M4 Junction 3-12 Smart Motorway (TR 010019)

Written representation from Reading Friends of the Earth for Deadline VII

From: John Booth - interested party Reading Friends of the Earth -
Registration identification number 10031717.

Project	SMART MOTORWAYS PROGRAMME
	M4 JUNCTIONS 3-12
Drawing title	ENVIRONMENTAL MASTERPLAN
	REGULATION 4(2)(e)
	SHEET 14 OF 61
	LOWER EARLEY

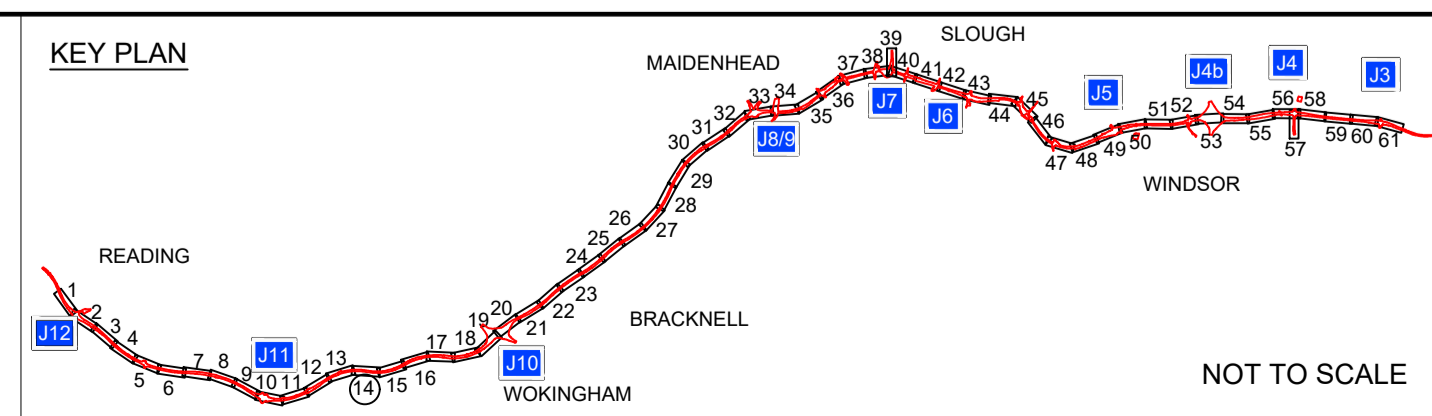
I supported Dr. Jorgensen's comment that the area close to Paddick Drive, Lower Earley, should be considered for noise screening. I said there is a BMX track and a newly-planted Community Orchard very close to the M4 at that location.

I also asked how much the additional marginal cost of improved standards of noise screening (e.g. 3.5 m instead of 2.5 m) would cost in context of the Smart M4 scheme as a whole.
